RE: Tilbuster Solar Farm – SSD 9619 – Response to Submissions - Revised Biodiversity Development Assessment Report

Attachment 1: Detailed BCD Comments – Tilbuster Solar Farm (SSD – 9619) – Response to Submissions – Revised Biodiversity Development Assessment Report

Figure 4-2 Koala and Pale-headed Snake Species Polygons

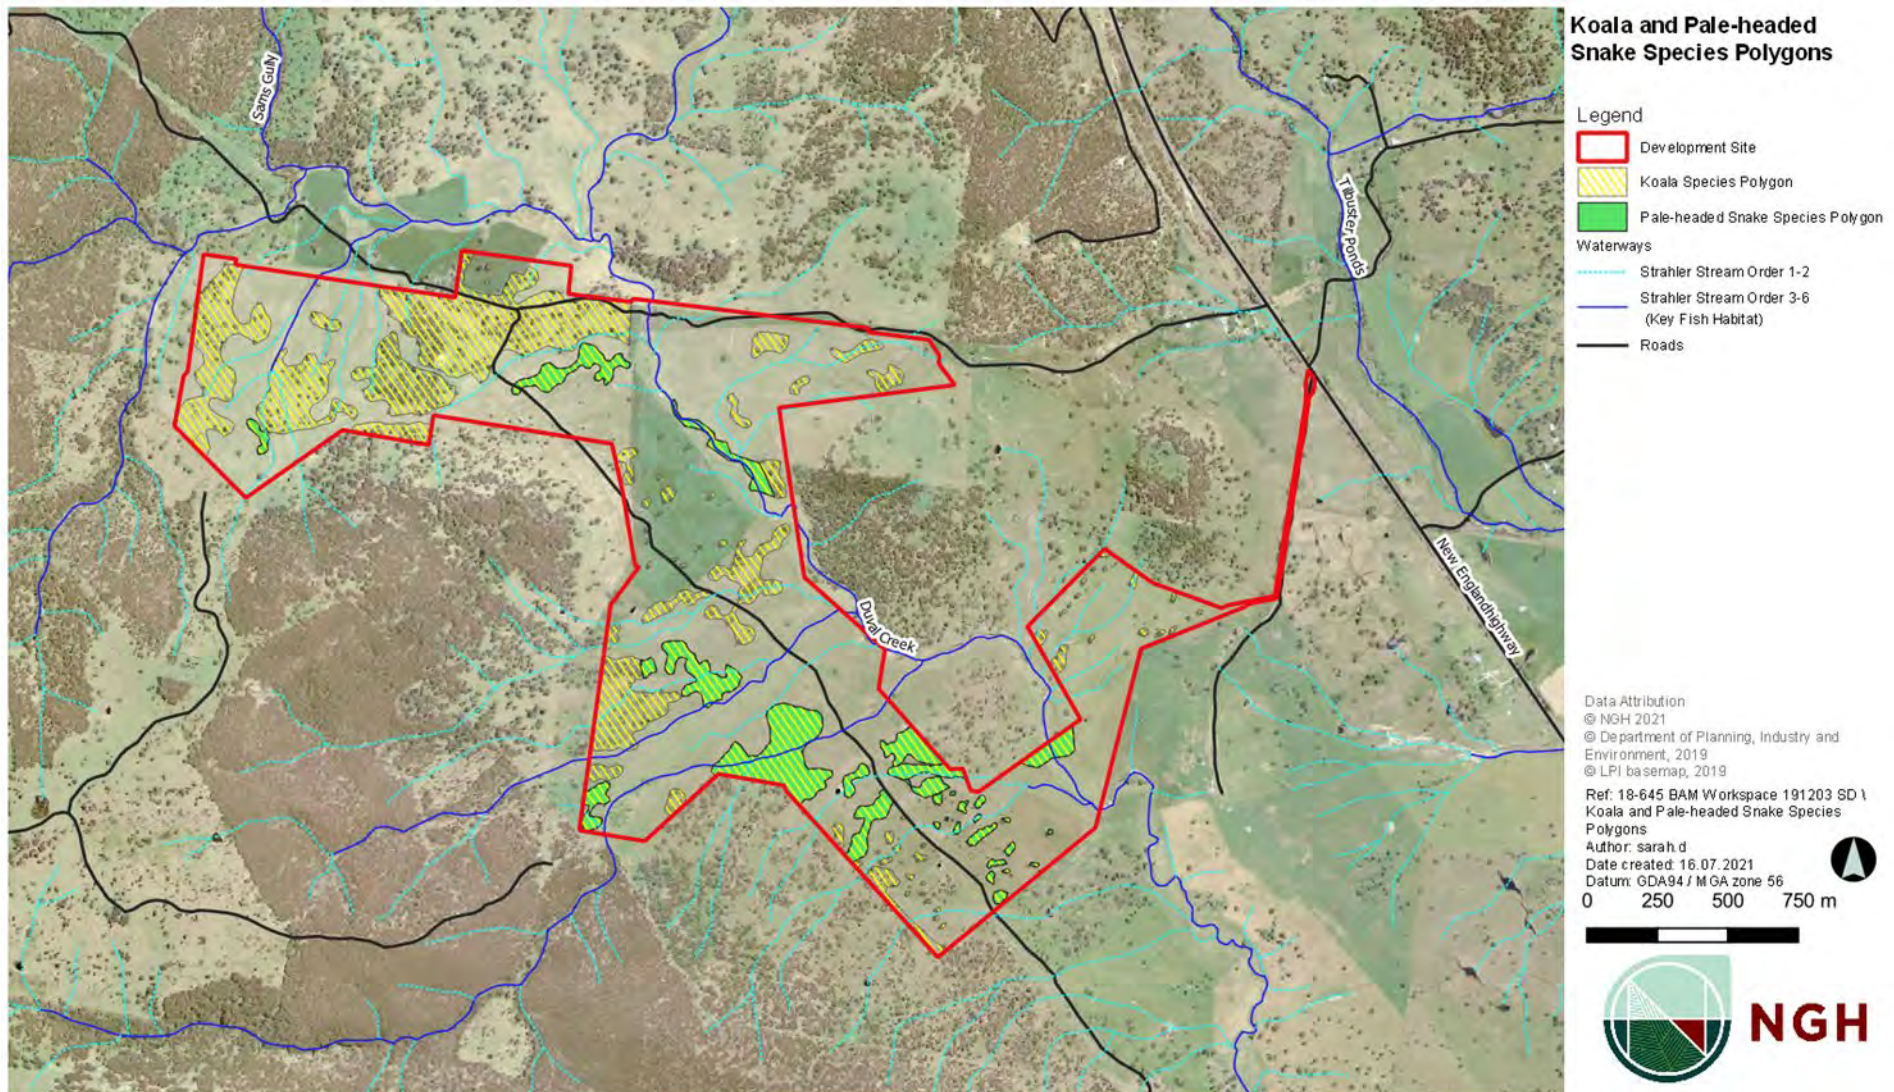
The BCD has identified an inconsistency in the total area of Koala habitat to be impacted by the proposed development.

On page 73 of the BDAR, the assessor has determined that 12.6 hectares of Koala habitat will be removed by the proposal, yet on page 81, the assessor states that a total area of 27.4 hectares of habitat will be removed. The lesser value of 12.6 hectares has formed the basis of the Koala species polygon for which an offset has been calculated.

The inconsistency between the total area of Koala habitat must be resolved. This would be best achieved by revising the species polygon, taking into consideration Section 6.4 of the BAM and the advice from the BCD BAM Support Team replicated in italics below:

6. The Koala species polygon must be revised in the BDAR so that it is mapped in accordance with the advice from the BAM Support Team.
7. A species polygon must also be prepared for the Greater Glider to enable an offset to be calculated in the BAM-C.

Figure 4-3 Greater Glider and Southern Myotis Species Polygons

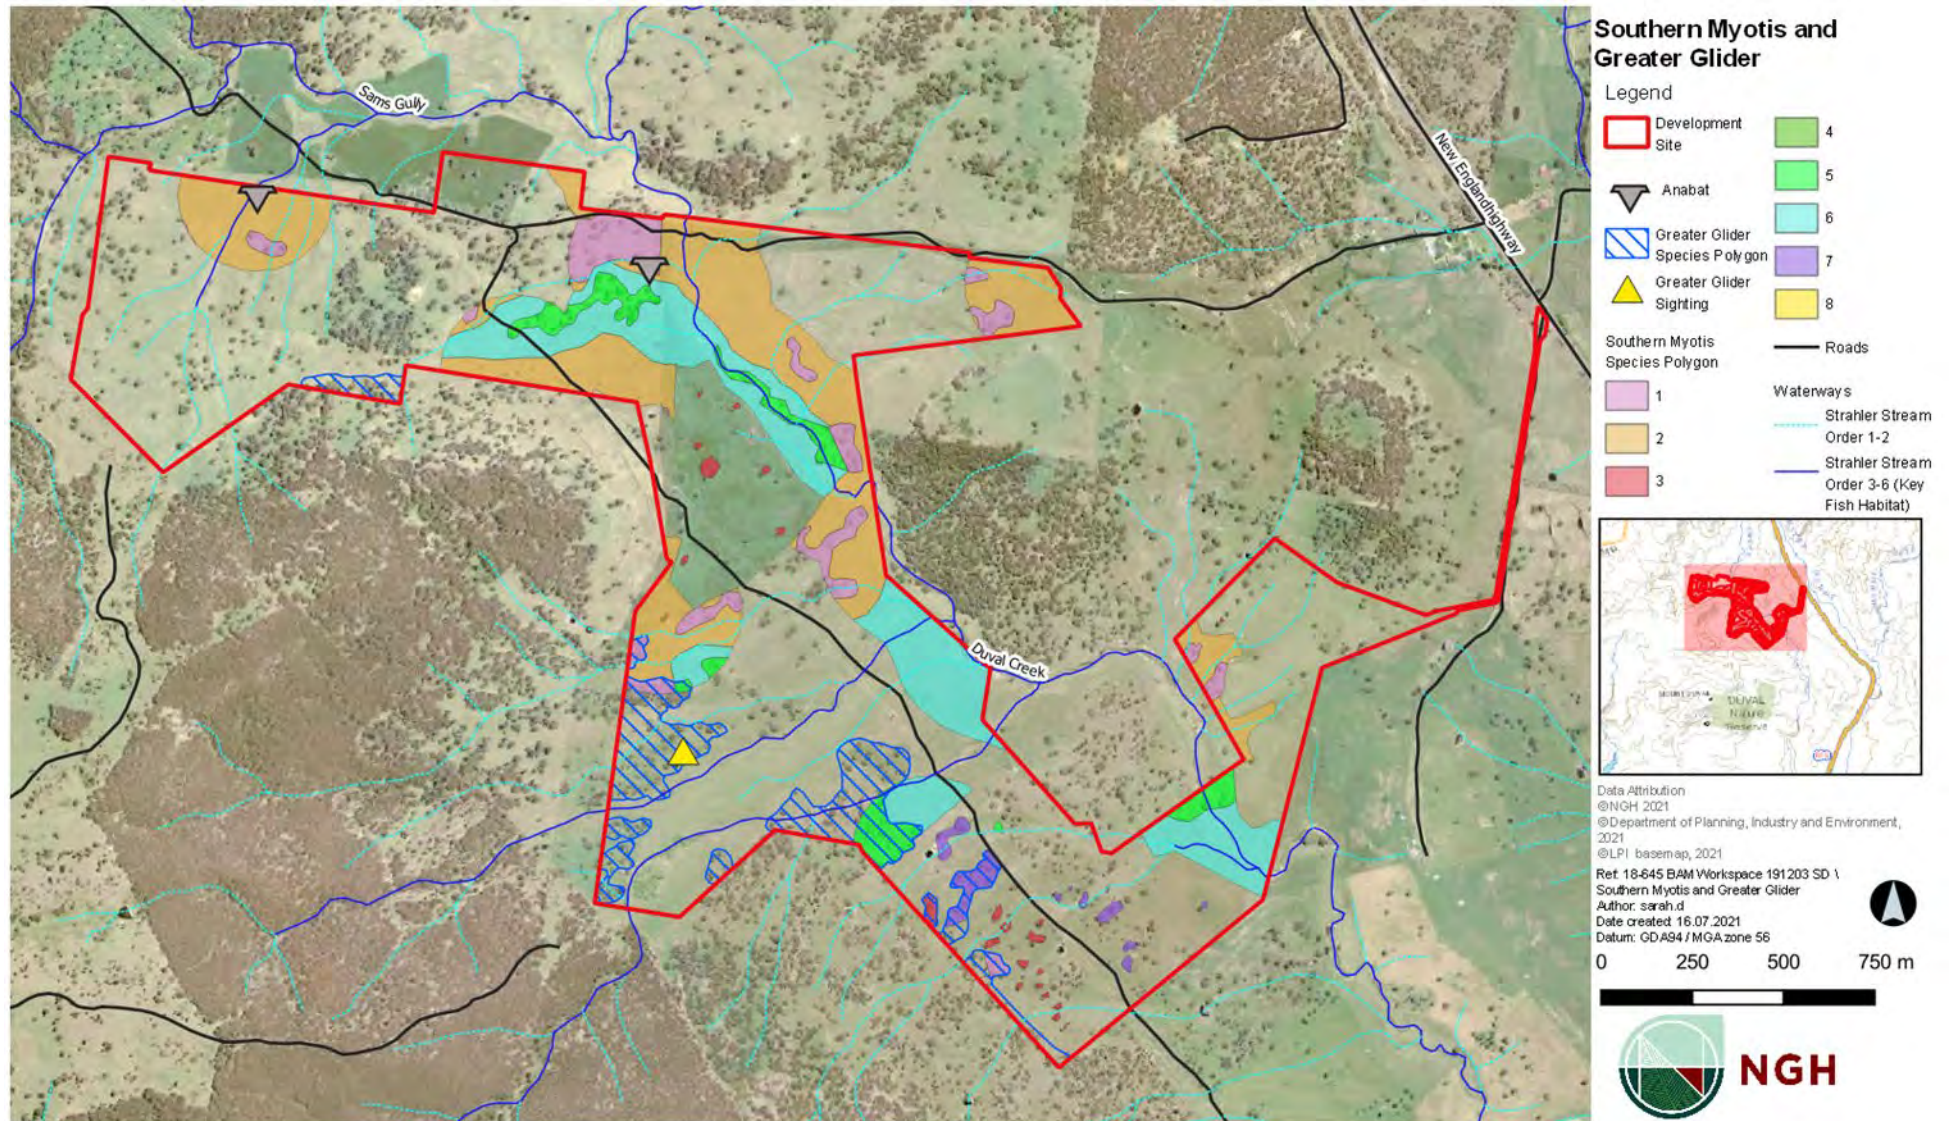
The BDAR does not include an assessment of the Greater Glider, which was recorded on the development site. This species is listed as a threatened species under the EPBC Act but is not listed as a threatened species under the BC Act. The BDAR must be amended to apply the BAM to the greater glider.

Figure 4-4 Bluegrass Field Traverses

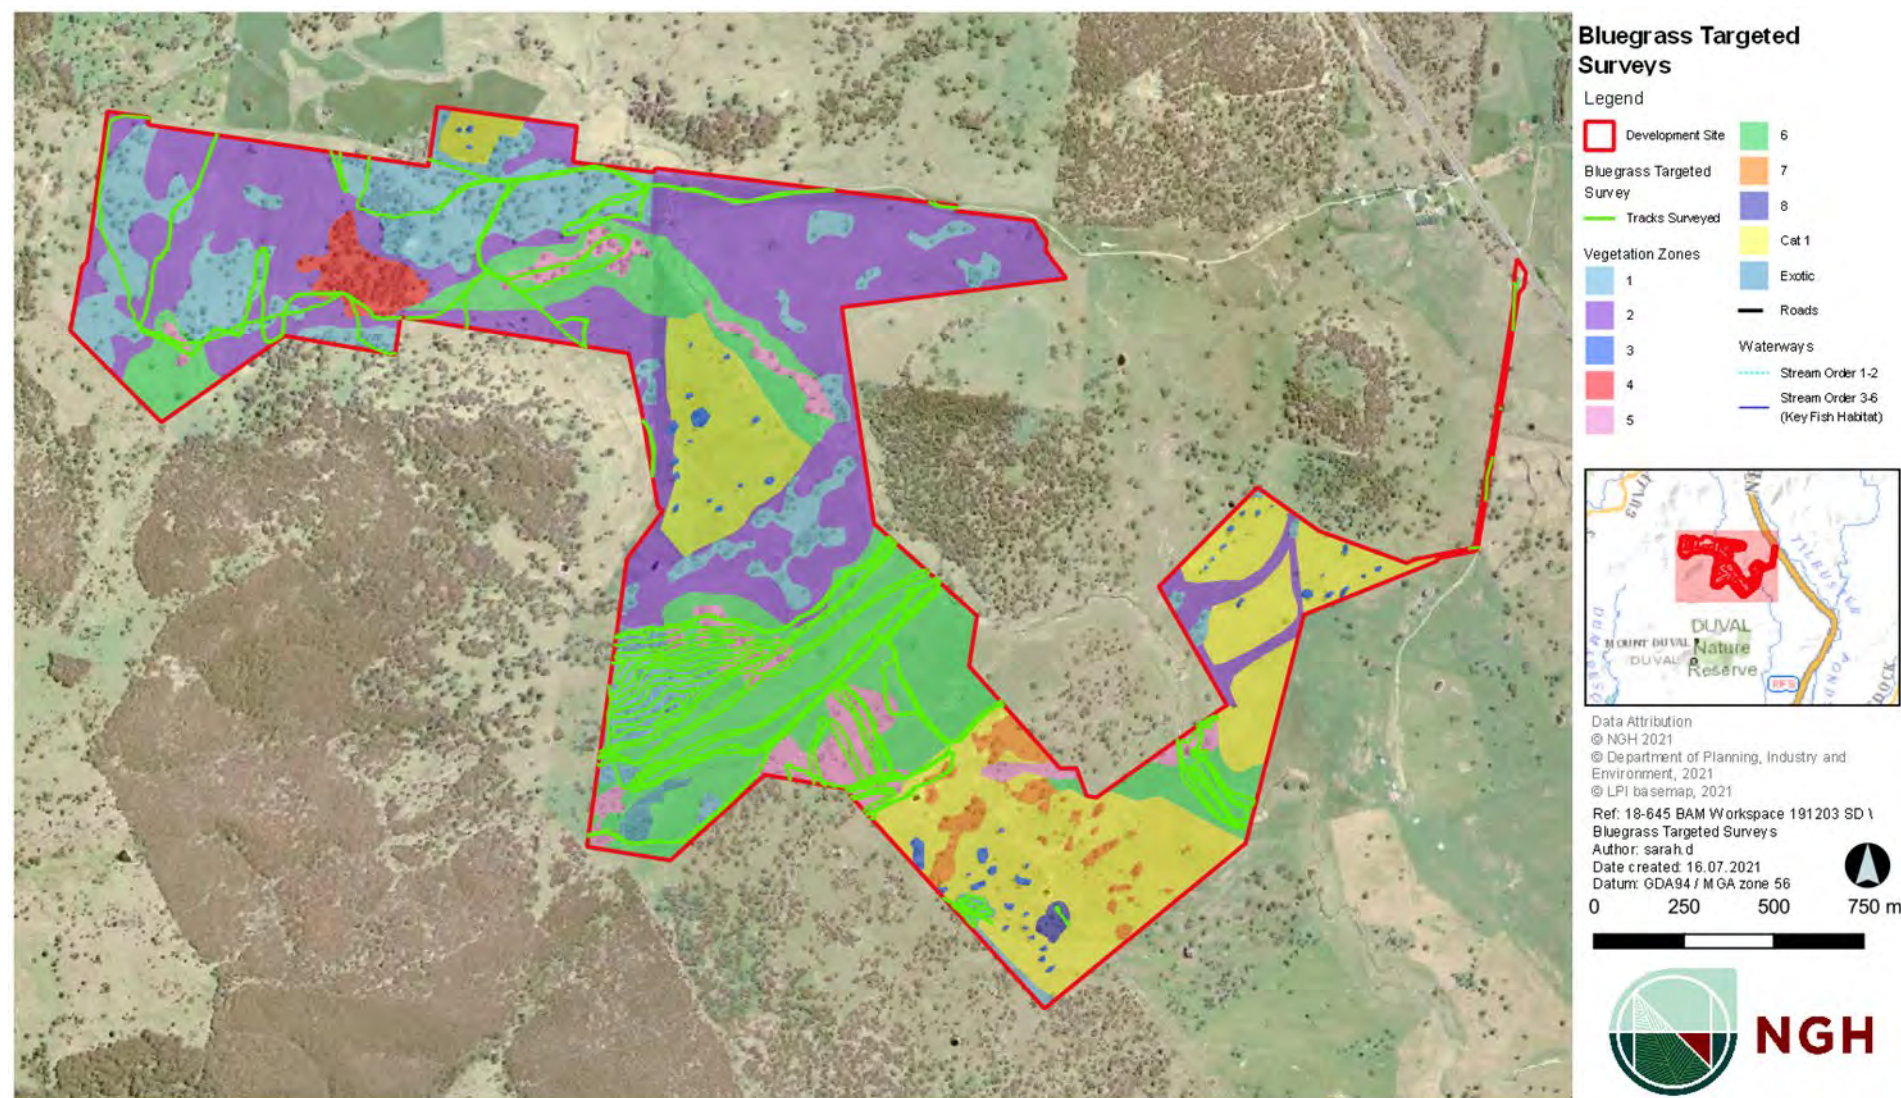
5. The BDAR must document the details of all targeted threatened plant surveys undertaken, including the techniques adopted, as well as the survey effort and timing, rather than simply stating that the surveys were consistent with the survey guidelines. In addition, where appropriate, the location of field traverses should be illustrated on a map and included within the BDAR.

In reviewing the BDAR we have noted that the description of the field survey effort for threatened plants states that searches were undertaken '*via parallel field traverses in accordance with the NSW Guide to Surveying Threatened Plants*'.

5. The BDAR should document the details of all targeted threatened plant surveys undertaken, including the techniques adopted, as well as the survey effort and timing, rather than simply stating that the surveys were consistent with the survey guidelines. In addition, where appropriate, the location of field traverses should be illustrated on a map and included within the BDAR.

Figure 6-4 Biodiversity constraints and the updated amended Development Footprint following BCD consultation

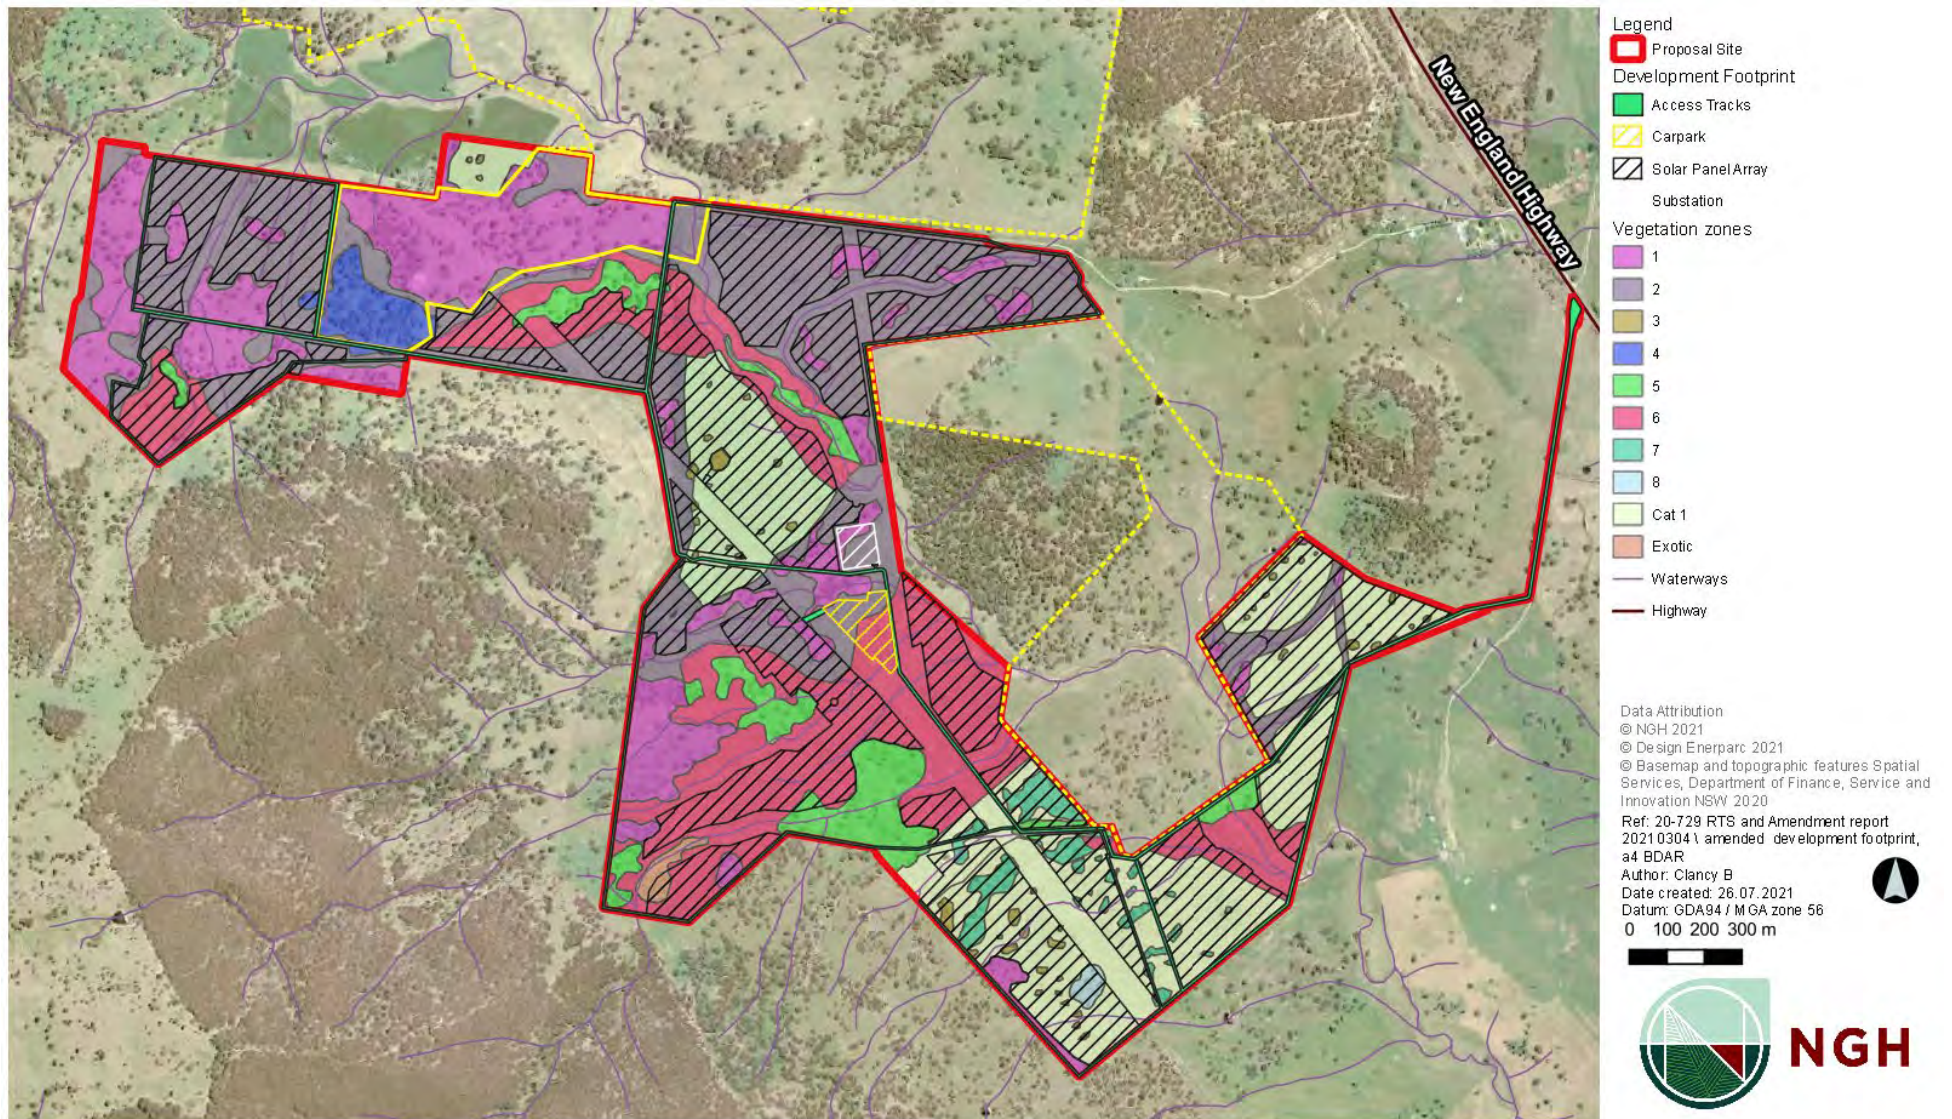
9. The development footprint should be revised to avoid the severing of connectivity at the location illustrated by the red circle in Figure 2 of Attachment 1 to this letter.

The BDAR also indicates that a small part of the development footprint will be located across what appears to be a north-south vegetated corridor (indicated by the red circle on the image below) which may be utilised by koalas, which are known to occur on site. Vegetation to the north of the footprint comprises the highest quality stand of grassy box gum woodland on the development site, which should be connected via habitat linkages to the south where other stand of native vegetation occur.

8. Further consideration should be given to avoiding impacts on high quality stands of the critically endangered ecological community White Box Yellow Box Blakely's Red Gum Woodland that have a vegetation integrity score of at least 33.
9. The development footprint should be revised to avoid the severing of connectivity at the location illustrated by the red circle in Figure 2 above.
